Our Ref: ABP-301908-18

Re: Greater Dublin Drainage Project consisting of a new wastewater treatment plant, sludge hub centre, orbital sewer, outfall pipeline and regional biosolids storage facility
Townlands of Clonshagh, Dubber and Newtown, County Fingal and Dublin City

Planning Application: No reference number but relates to the Greater Dublin Drainage Project

Description of the Development: Microtunnelling at R122 at Baleskin Centre where 2 x planning notices for this development is located. Odour Control Unit installation.

Drawing Title:
ODOUR CONTROL UNIT PLAN AND ELEVATION

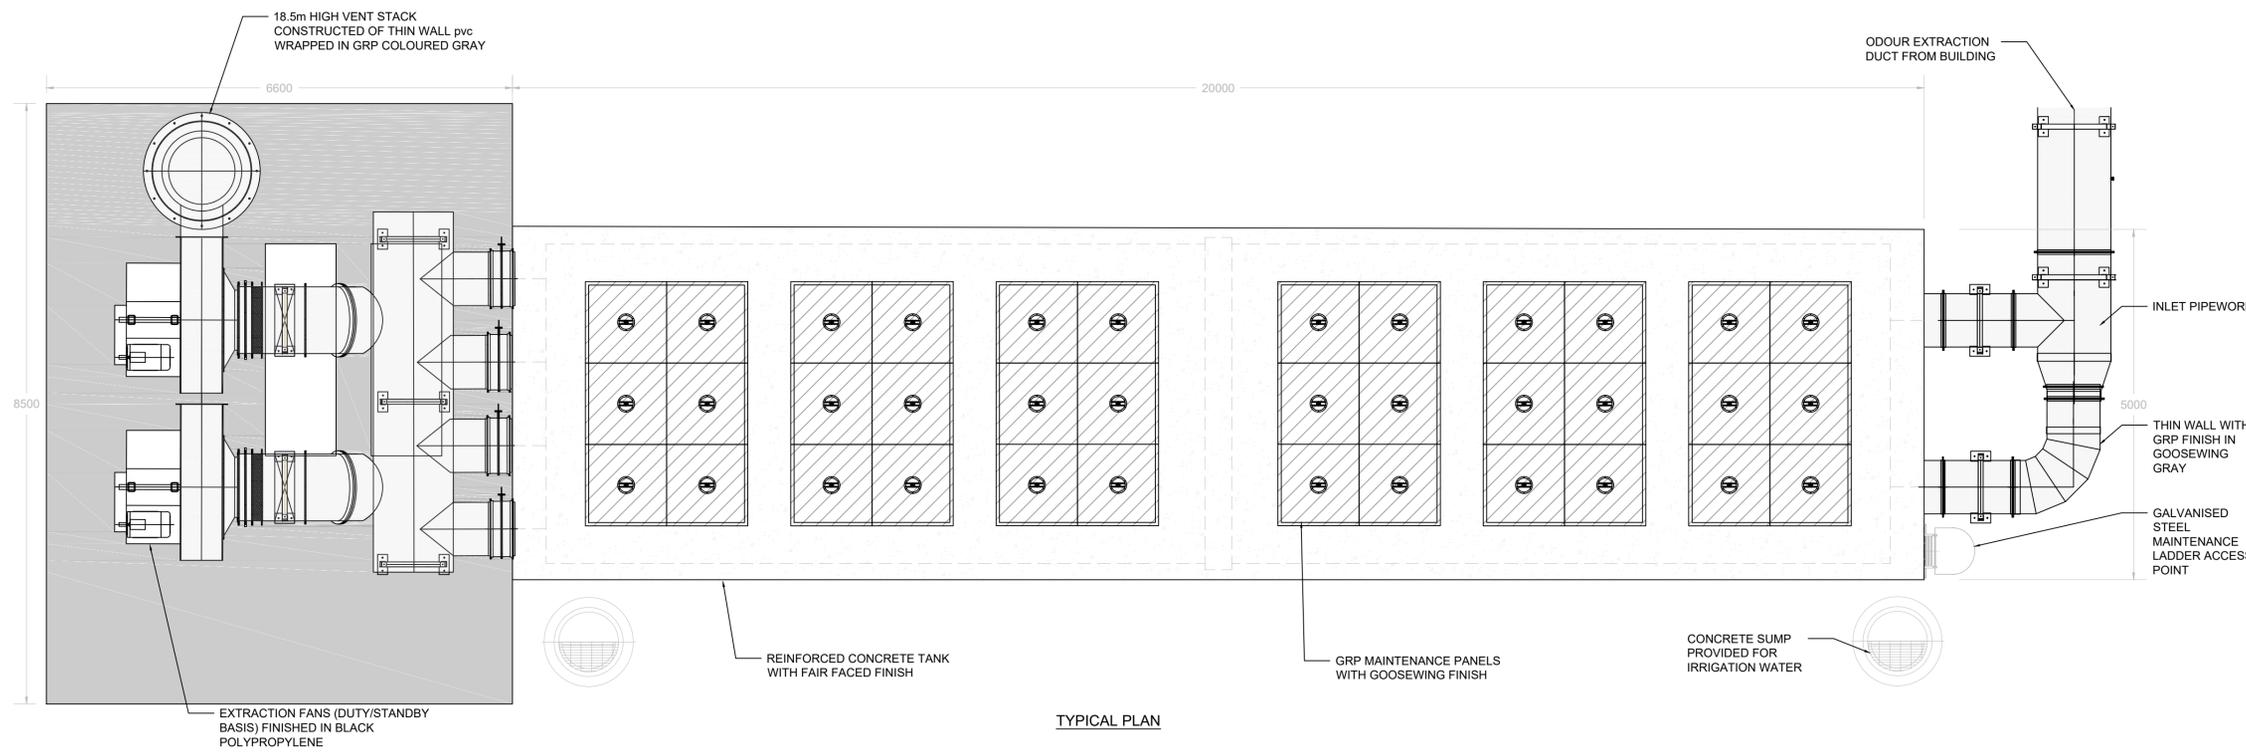
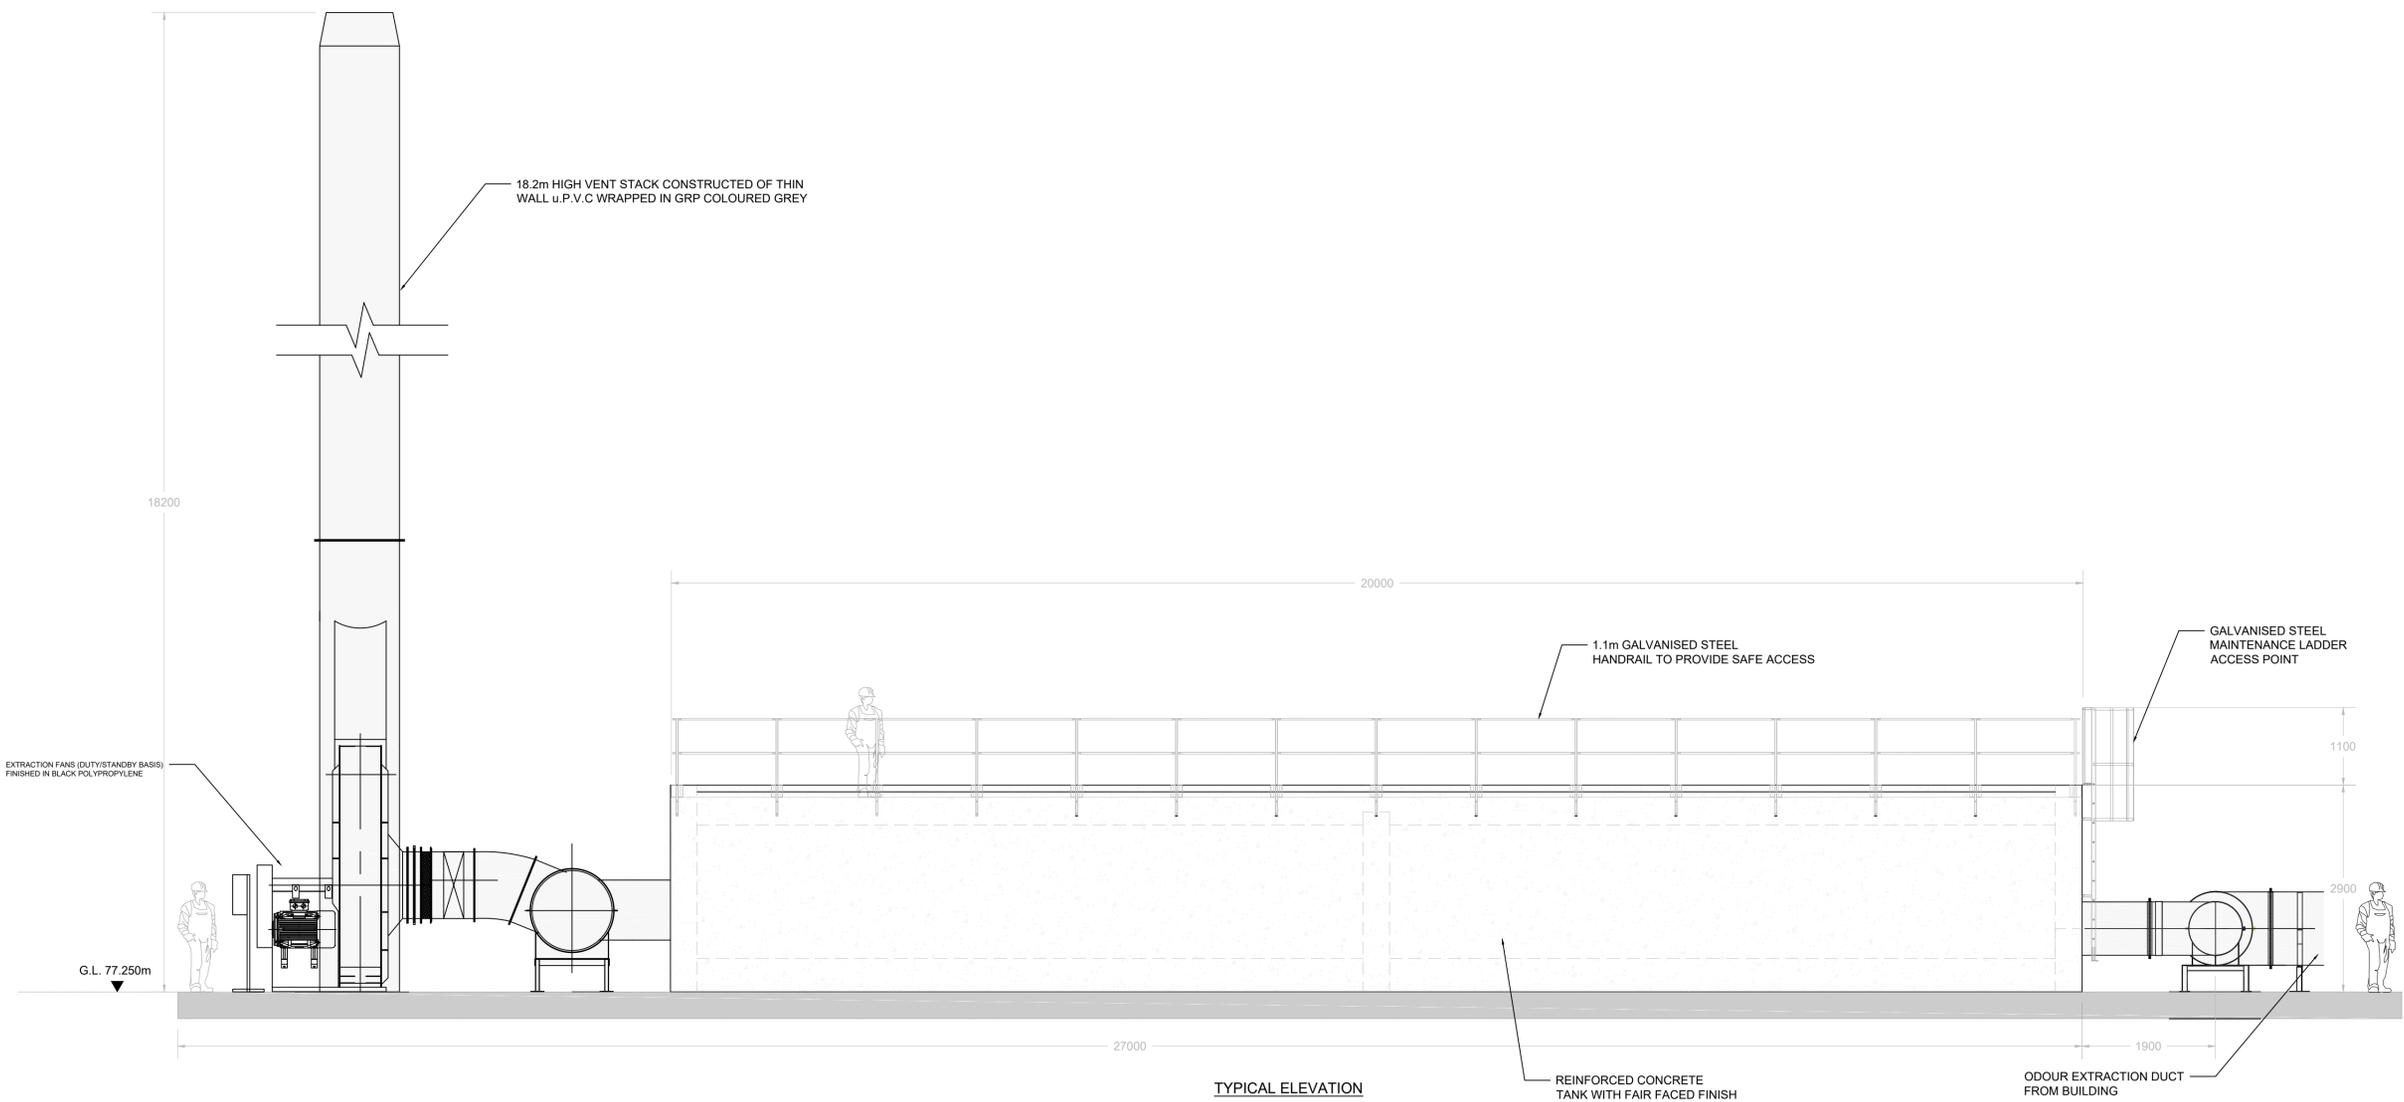
We have odour concerns with these proposed 'odour control units,. From research we understand these buildings will be 5 metres high.

Why are they only 5 metres high? As per our research they are normally up to 25metres high and above.

- Who is controlling and monitoring these odour control units?
- We want reassurances that contingencies are in place in relation to potential flooding and ESB break down.
- In relation to digging of the area is the biodiversity of this area been considered for the area as there will be a disturbance for the natural habitat of the wildlife?
